**RE: Montoya Street Townhomes (File: H12D019A)
Tracts A1 and A2 Lands of David Maciel
Montoya St NW between Floral Rd and I-40
Grading Plan and Drainage Report
Engineer's Stamp Date – 12/16/2015**

Based upon the information provided in your submittal received 12-16-2015, the above referenced Grading Plan and Drainage Report is approved for Preliminary Plat, Final Plat and Grading Permit.

RE: **Montoya Street Townhomes (File: H12D019A)**
Tracts A1 and A2 Lands of David Maciel
Montoya St NW between Floral Rd and I-40
Grading Plan and Drainage Report
Engineer's Stamp Date – 10/15/15

Based upon the information provided in your submittal received 10-15-15, the above referenced Grading Plan and Drainage Report cannot be approved for Preliminary Plat, Final Plat and Grading Permit until the following comments are addressed.

ENGINEER'S SEAL	MONTOKA STREET TOWNHOMES	DRAWN BY WCMJ
	DAVID SOULE	GRADING AND DRAINAGE PLAN	DATE 10-15-15
	10/15/15		21523-LAYOUT-8-05-15
DAVID SOULE P.E. #14522		1806 CENTRAL AVENUE SE SUITE 201 ALBUQUERQUE, NM 87106 (505) 872-0999	SHEET # JOB # 21523

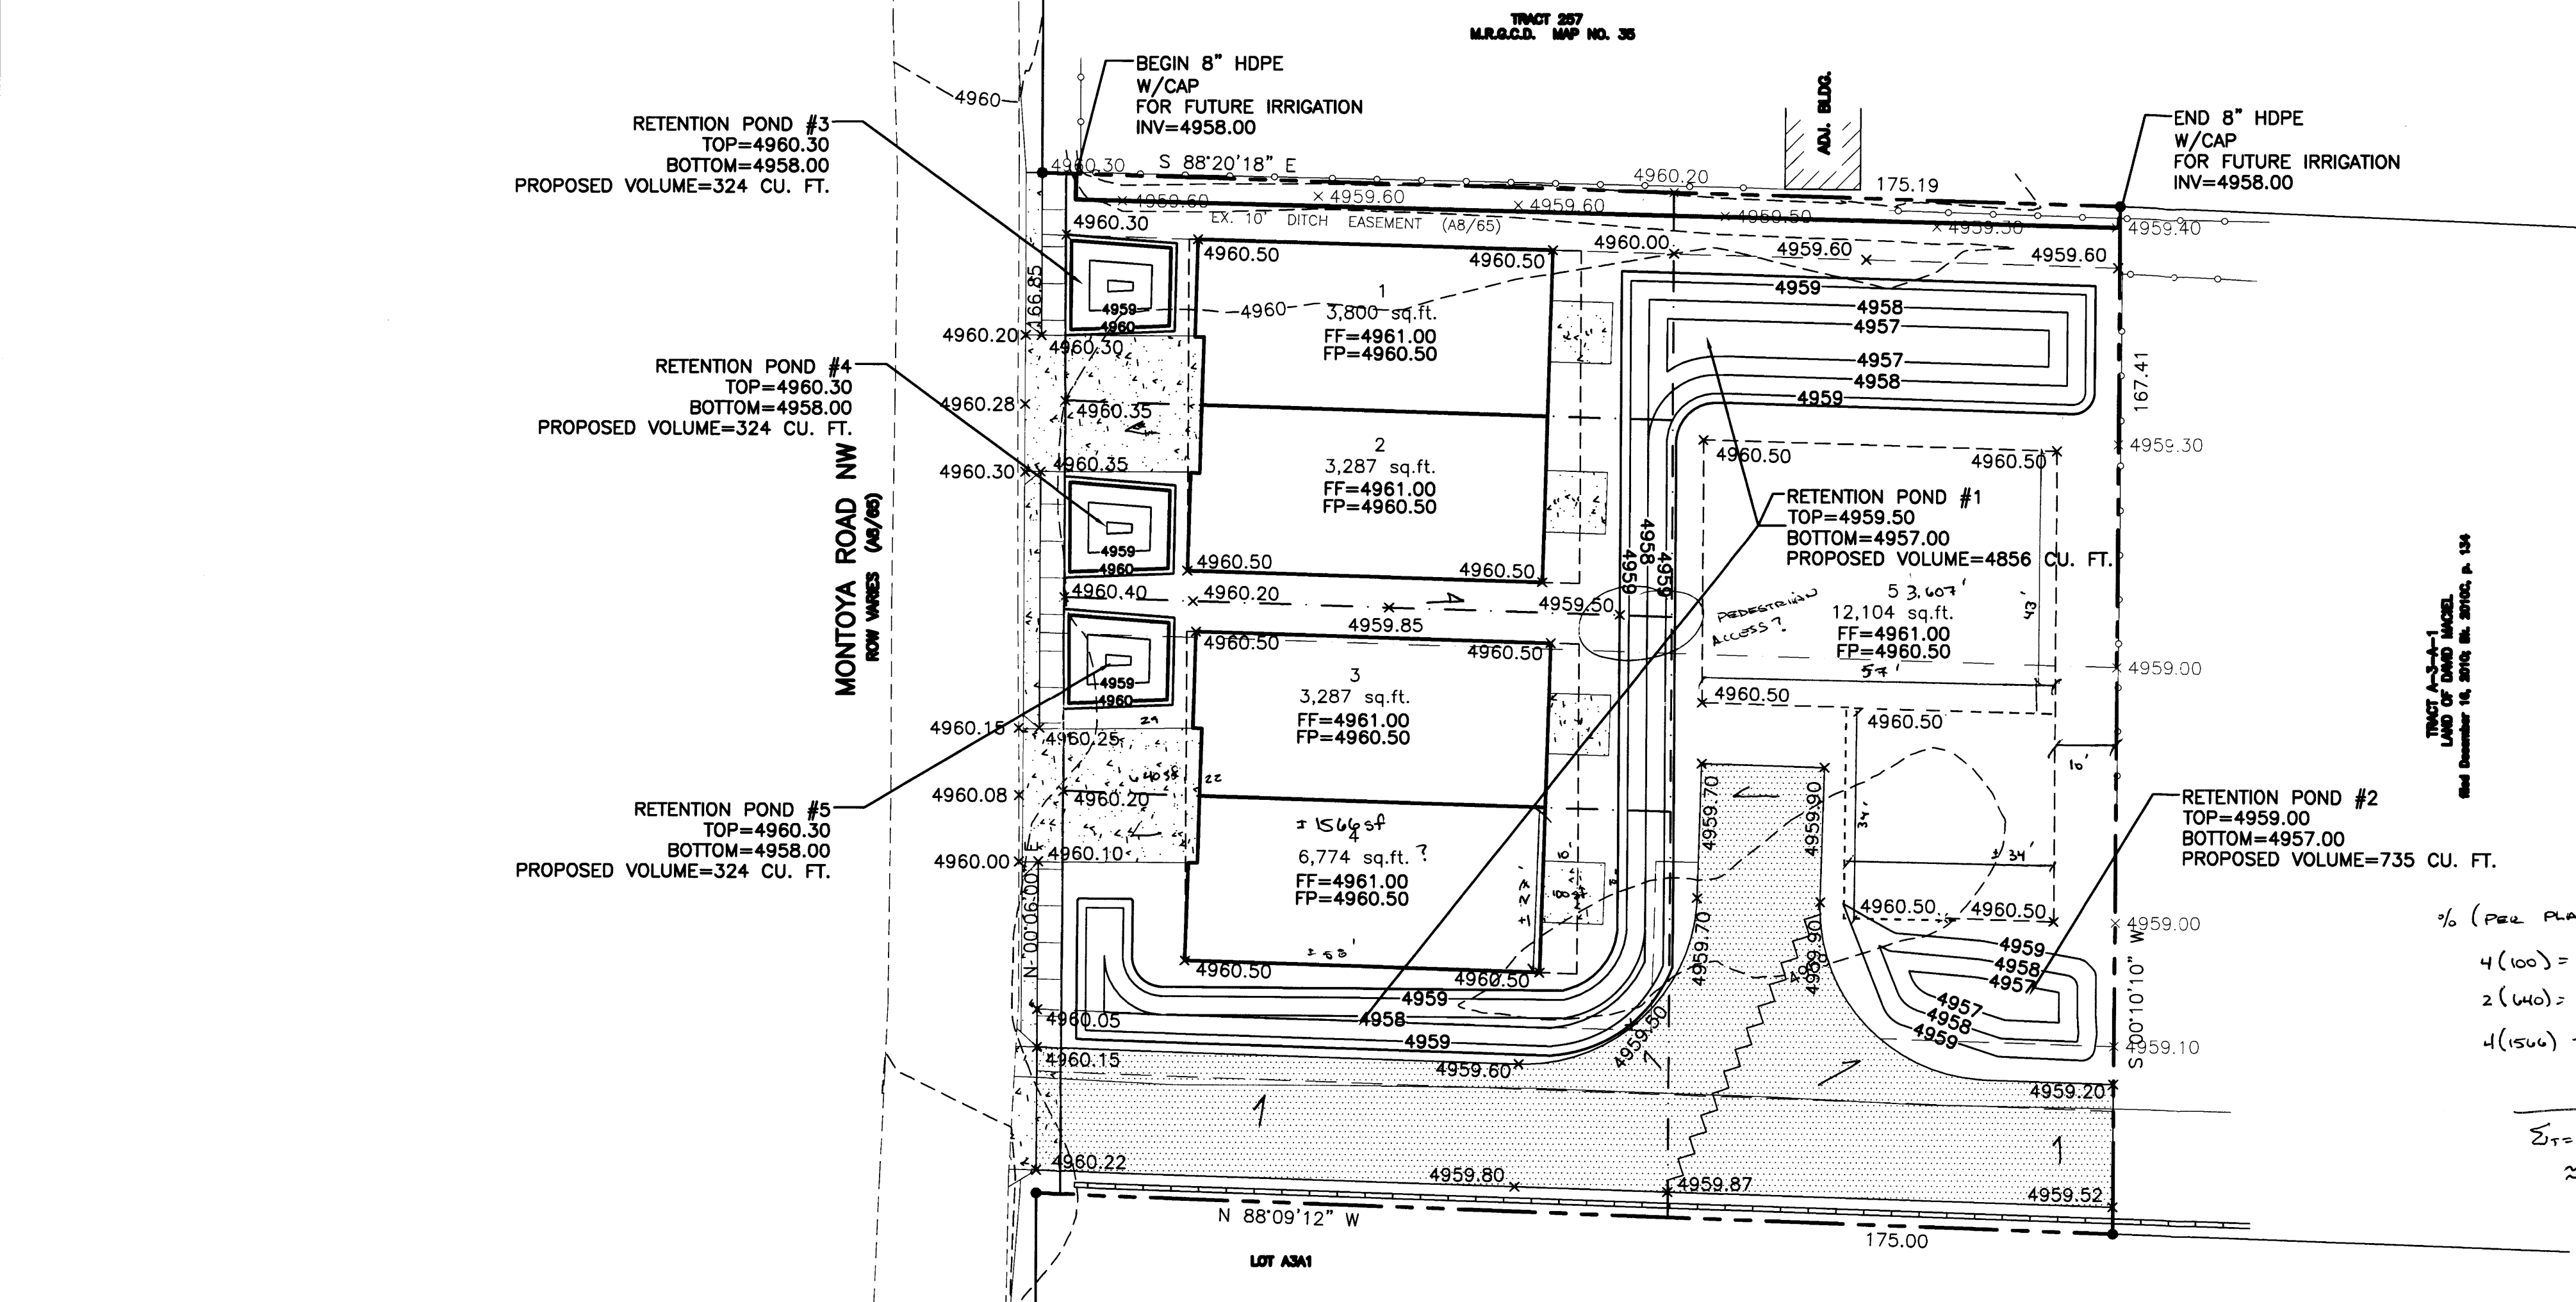
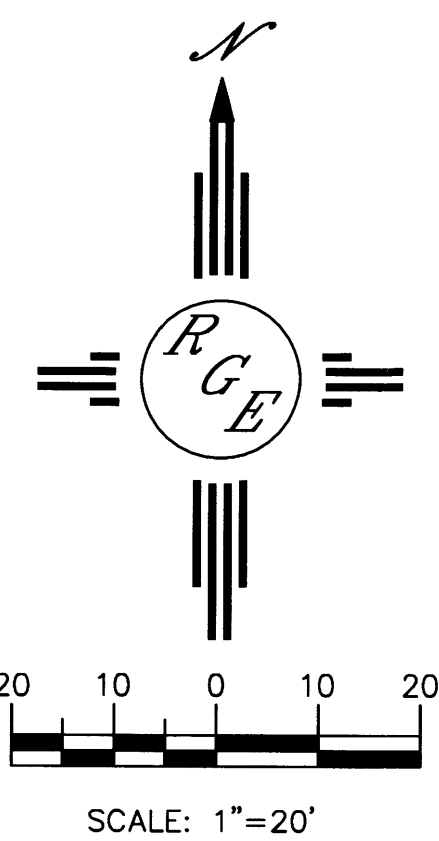
- Provide drainage flow areas to better identify overall site drainage patterns. **ADDED BASIN MAP** ✓
- Provide roof flow direction and outfall locations. **ADDED TO PLAN** ✓

- Clearly identify and define property lines. **"** ✓
- Clearly identify the location and limits of the 10 ft Ditch Easement located on the north property line. **"** ✓

- The Drainage Report indicates flows from a storm event exceeding the 100-yr, 6 hr storm event will discharge to Montoya Street. Per the spot elevations identified on the Grading Plan, it appears flows will be directed east away from Montoya Street. Show on the Grading Plan how this will be achieved. **REVISED REPORT TO CORRECT** 10-DAY

- The Drainage Report states the platting action will allow for cross lot drainage easement on all parcels yet the Drainage Report identifies flows to be retained onsite or discharged onto Montoya Street during a larger design storm. Provide offsite flow information and how offsite flows will be managed onsite. **ADDED BASIN MAP**

- A scale check on the area for townhomes 1-5 appears as though the area provided is incorrect. Re-check the areas to ensure the information is correct. **CORRECTED**
